From: [Aulick, Hannah](#)
To: [Strange, Bonnie S.](#); [Rodenbeck, Jay B.](#); [Andrew Bowman](#)
Cc: [Woffley, Tolene](#); [Webb, Robert L.](#); [O'Neill, Sean](#); [Garcia, Jayson A.](#); [Charles Moseley](#)
Subject: RE: ! RE: PR-2021-006006 DFT Site Plan Case (BCE#12735)
Date: Friday, April 12, 2024 10:55:24 AM
Attachments: [image004.png](#)
[image005.png](#)
Importance: High

I have copied our Planning and Forestry staff in this message, who will review the attachments you sent me in response to the conditions of approval in the NOD for the Site Plan Administrative DFT featuring the expansion of the fuel station and canopy at the Coors Costco, PR-2021-006006.

# LANDSCAPE PLANTING PLAN

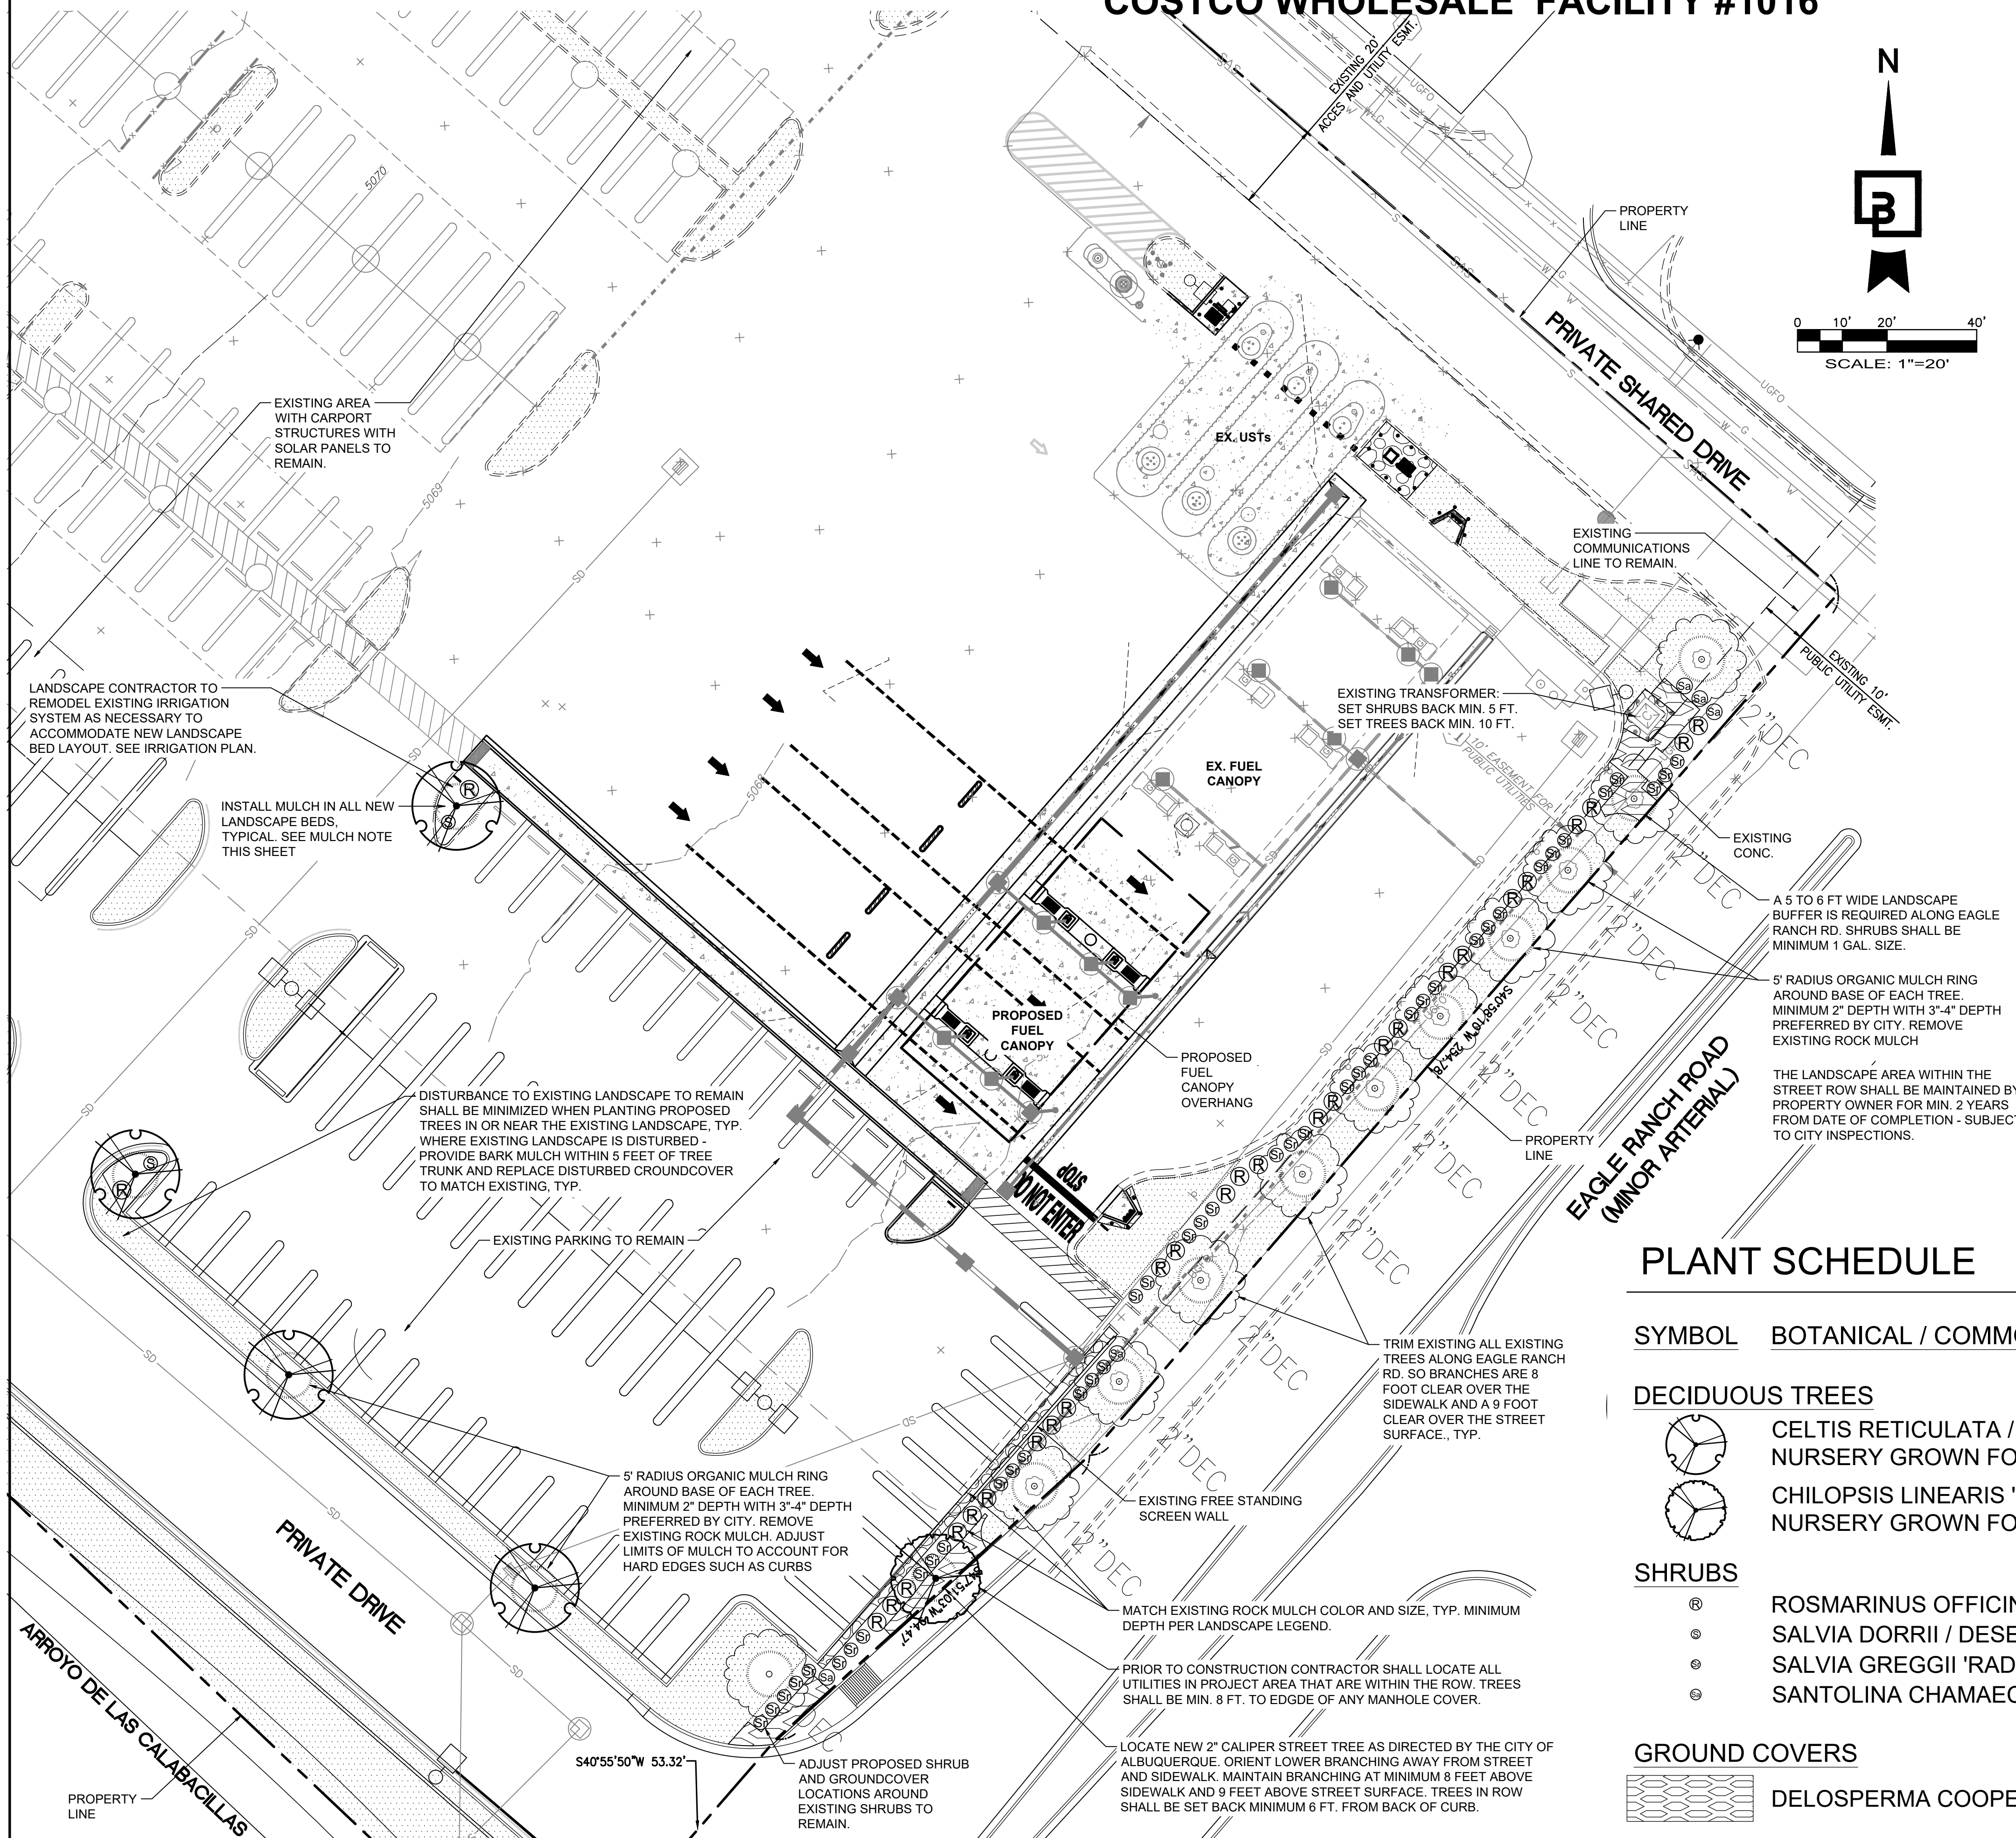
2. Please modify your Tree Planting Detail to show a 5' radius ring of **organic mulch** around the trees. Please see the code below for your reference: 5-6(C)(5)(e) **Organic mulch** is required as ground cover under trees within a 5-foot radius around the tree trunk, but not directly against the trunk. **In these areas, weed barrier fabric is prohibited.** (See figure below.)

Please make sure you call it out as **Organic Mulch**.

# LANDSCAPE IRRIGATION PLAN

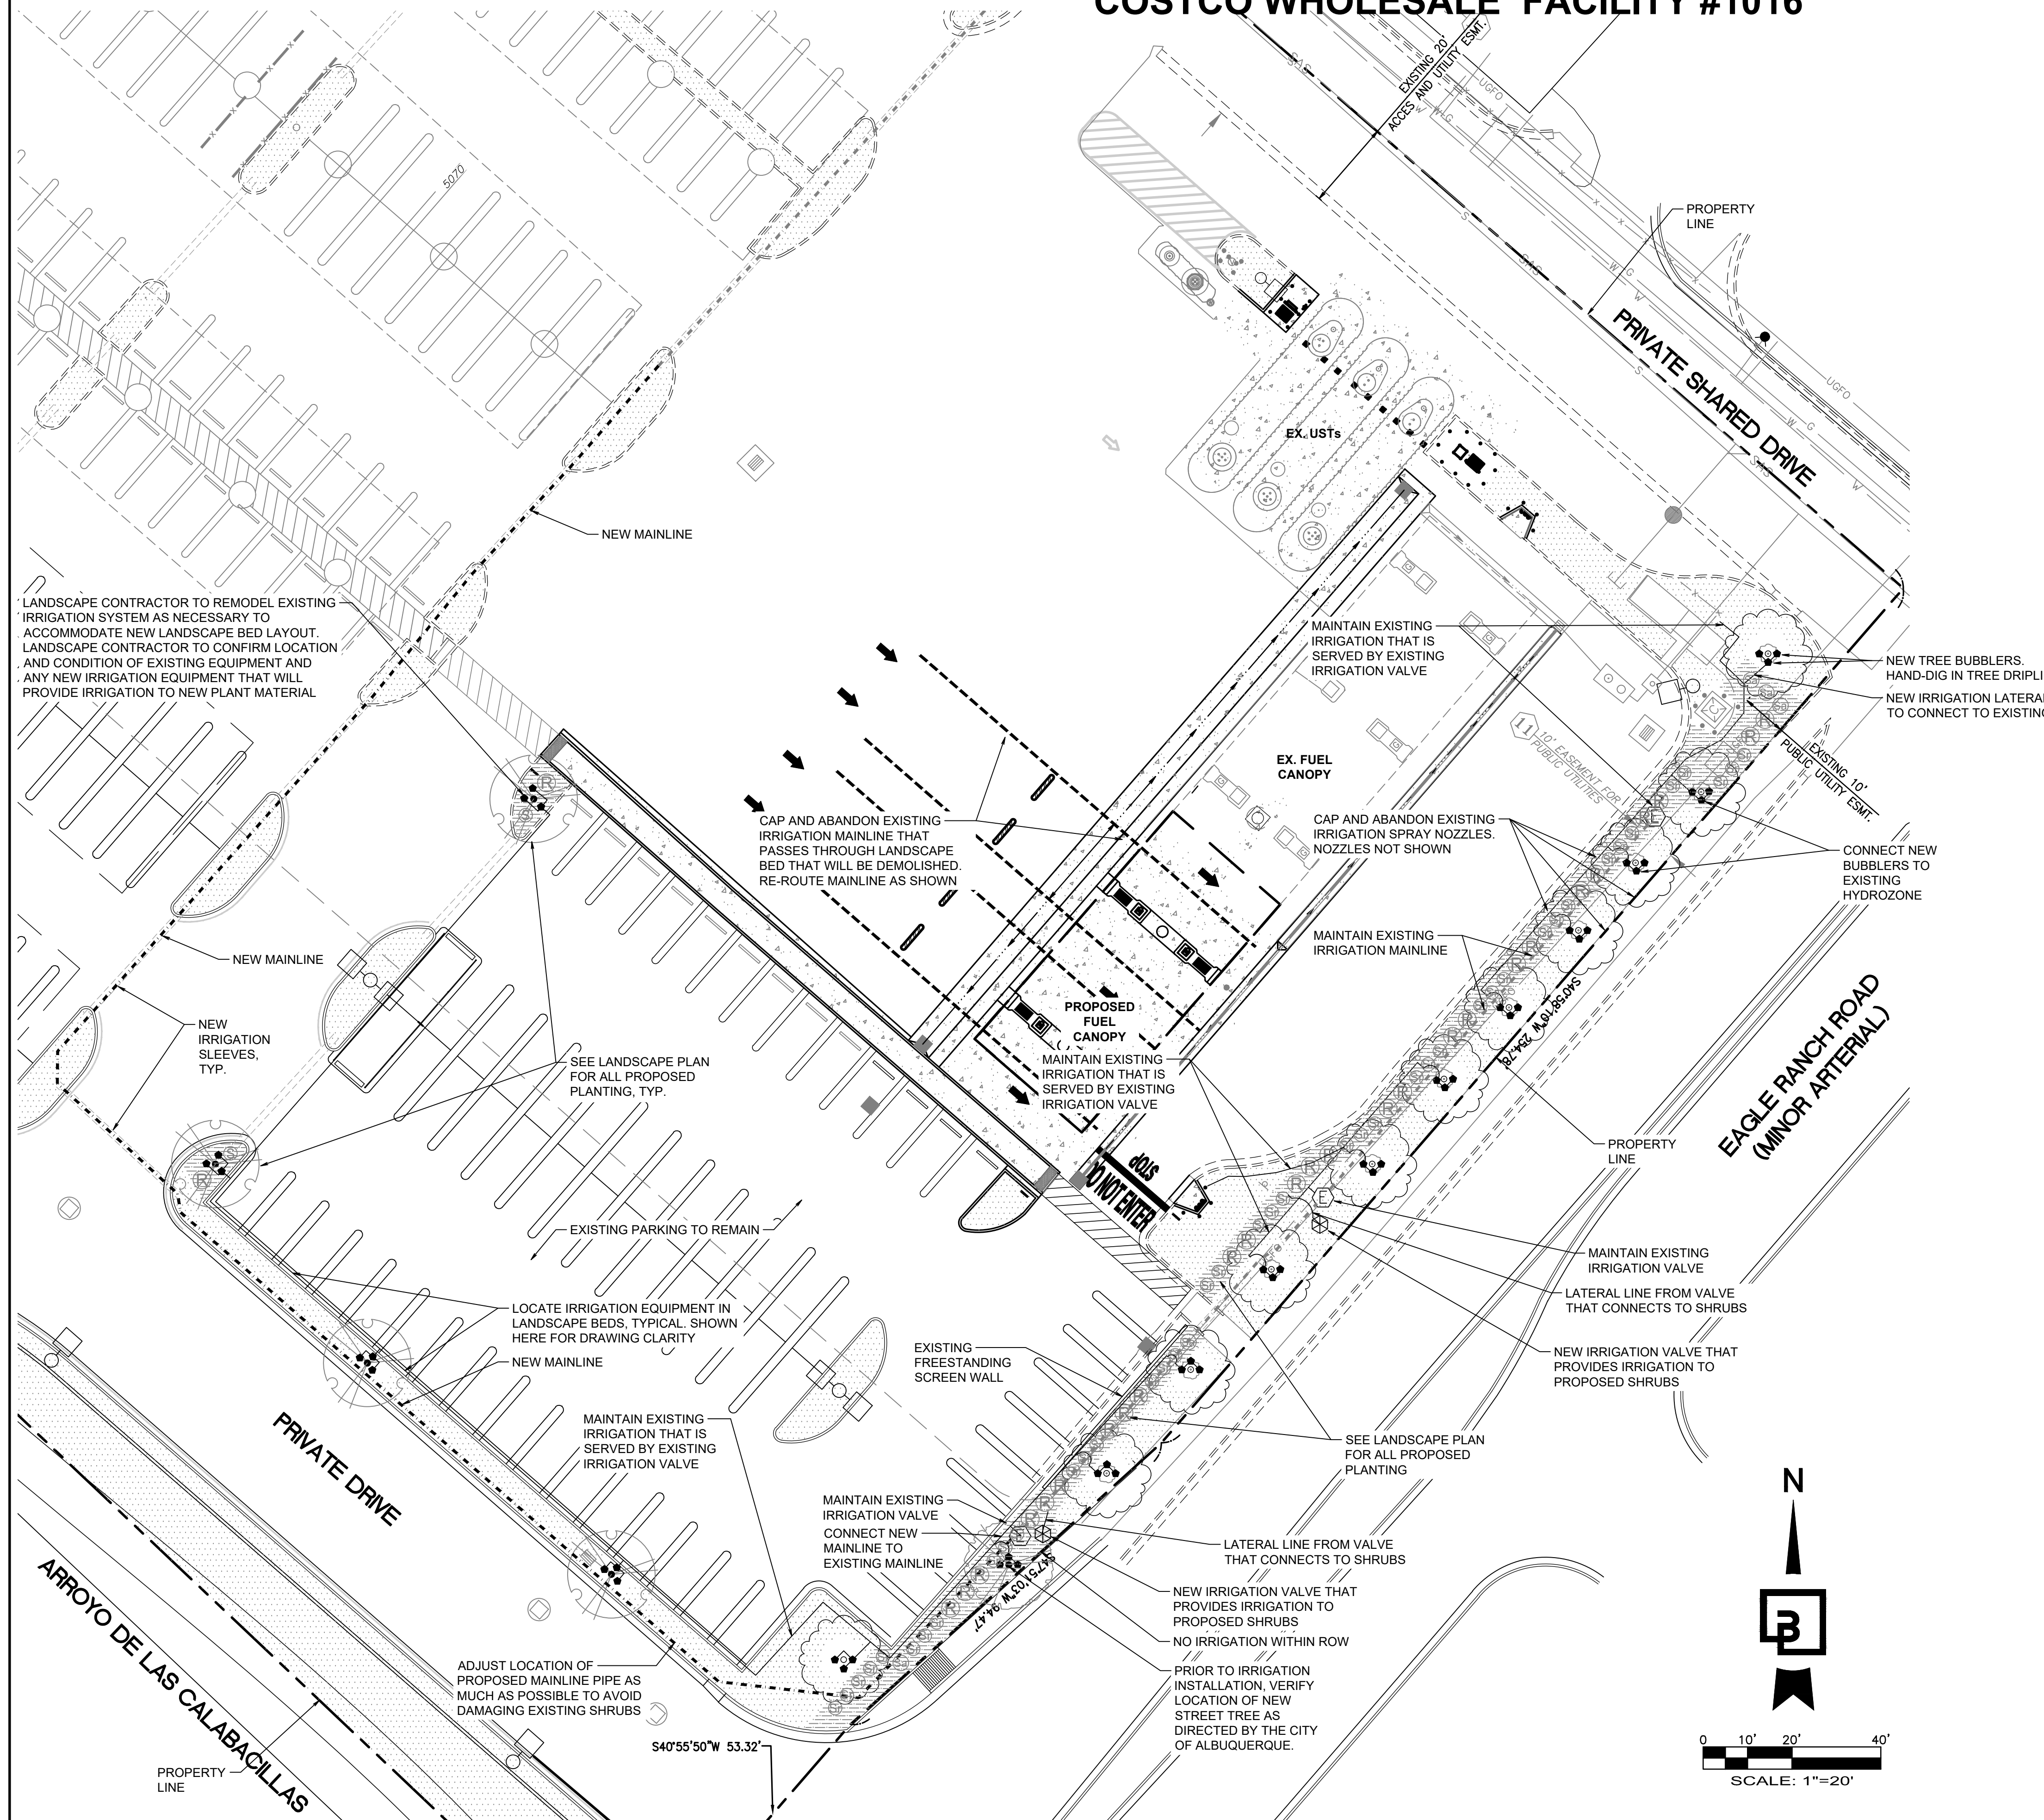
1. Your irrigation plan is not showing irrigation to 4 of your new trees as well as your newly proposed shrubs. Please clarify.
